Re: **Marysville Corporate Center – BSP (PA22004)**
3rd Round Response Letter
Project Number 2200444.00

In response to your plan review checklist dated January 10, 2023, we have addressed the items below, with our responses following your comments.

SEE SHEET 10 OF 13

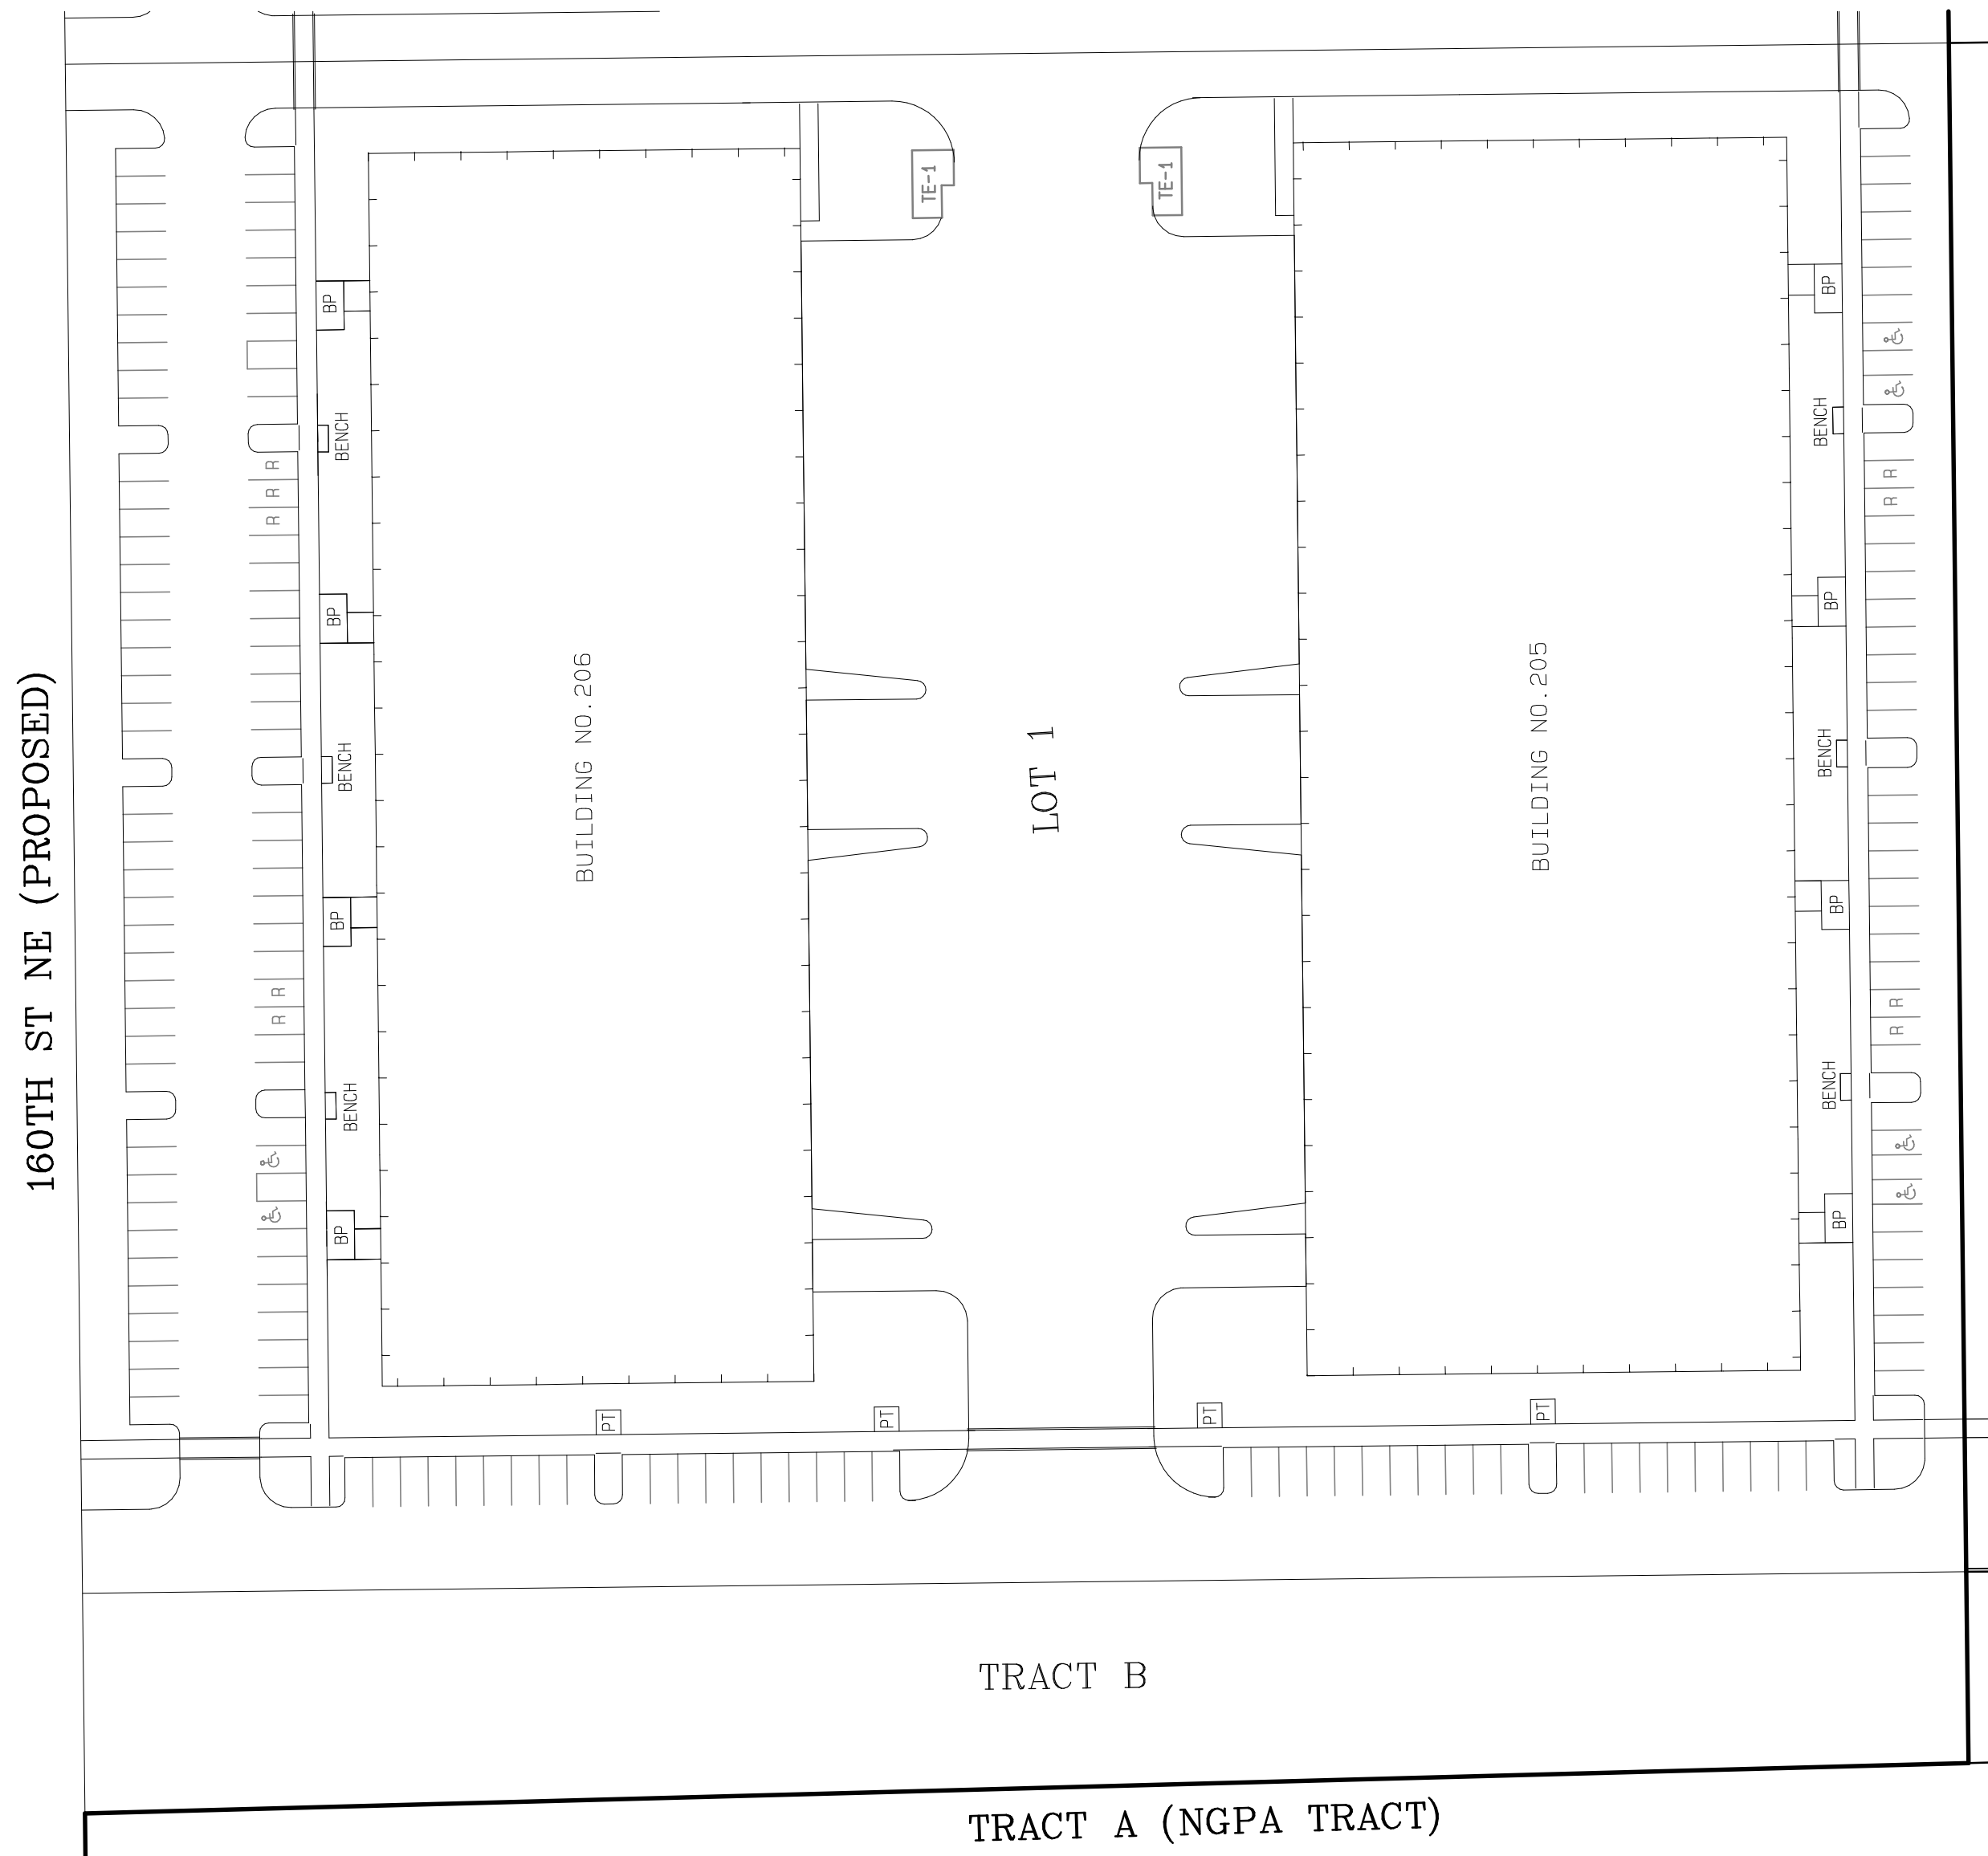
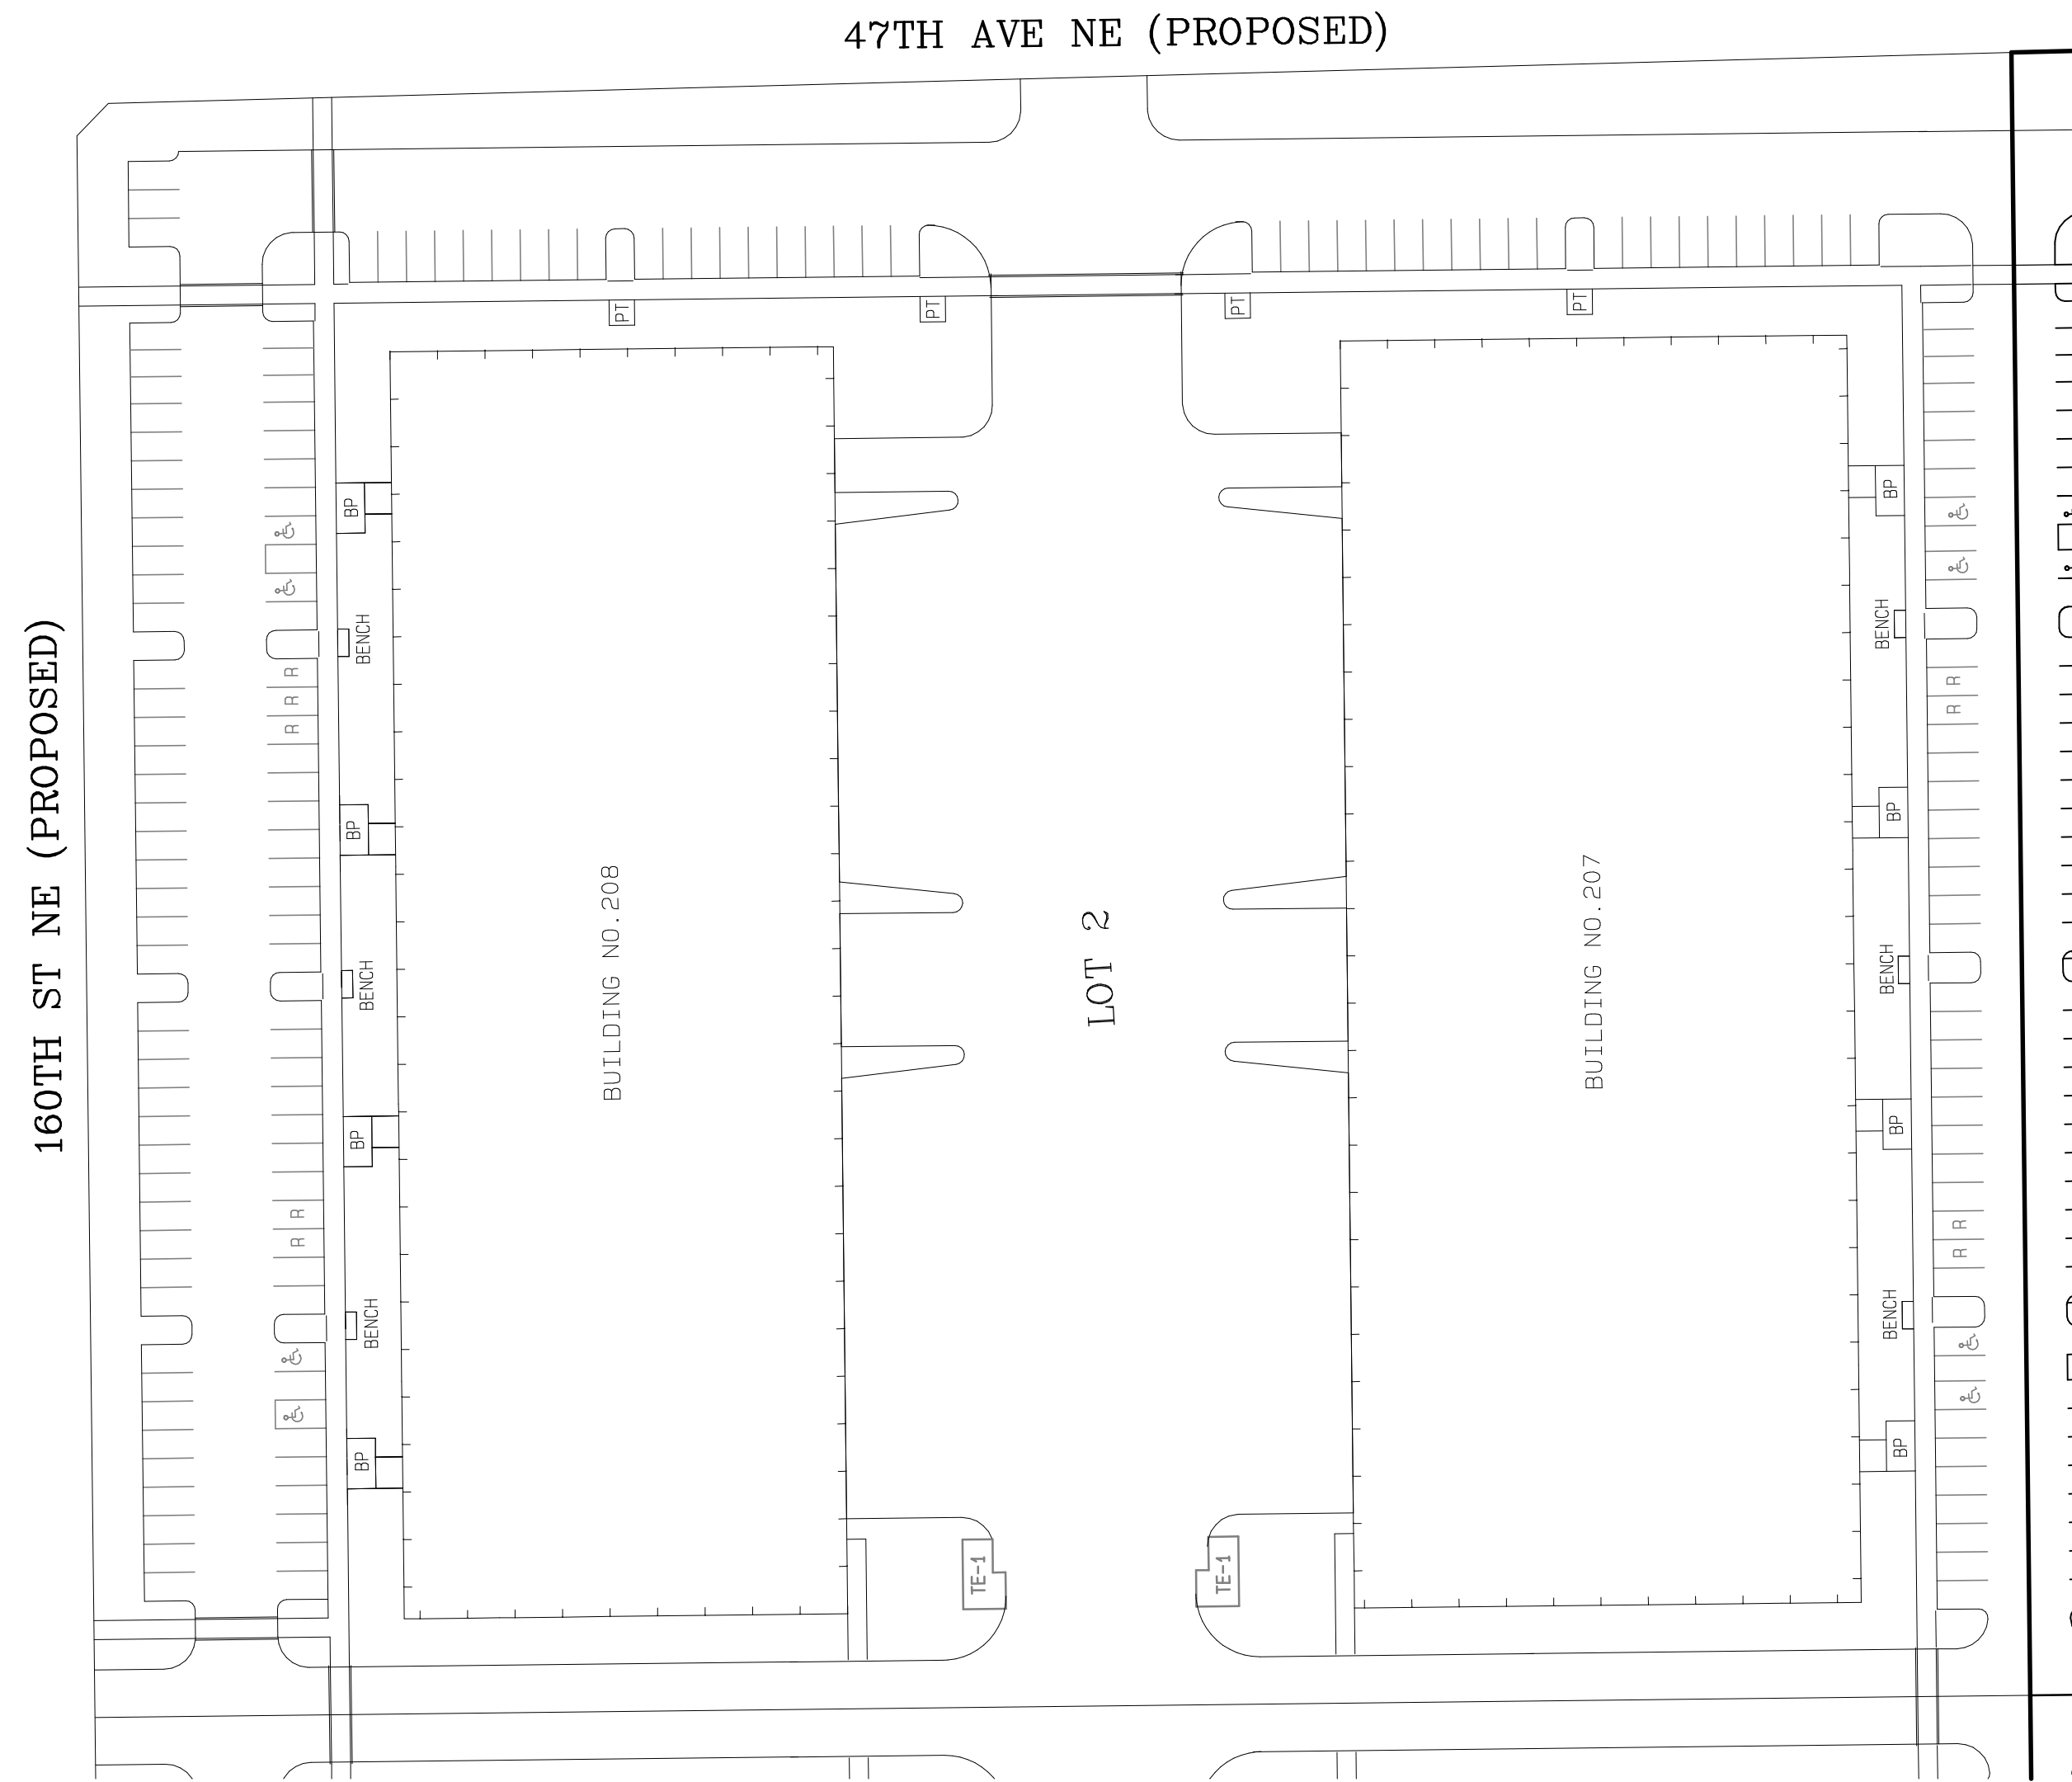
6. *Provide ADA parking calculations and locations.*

Response: ADA parking calculations and locations are shown on each respective BSP sheet.
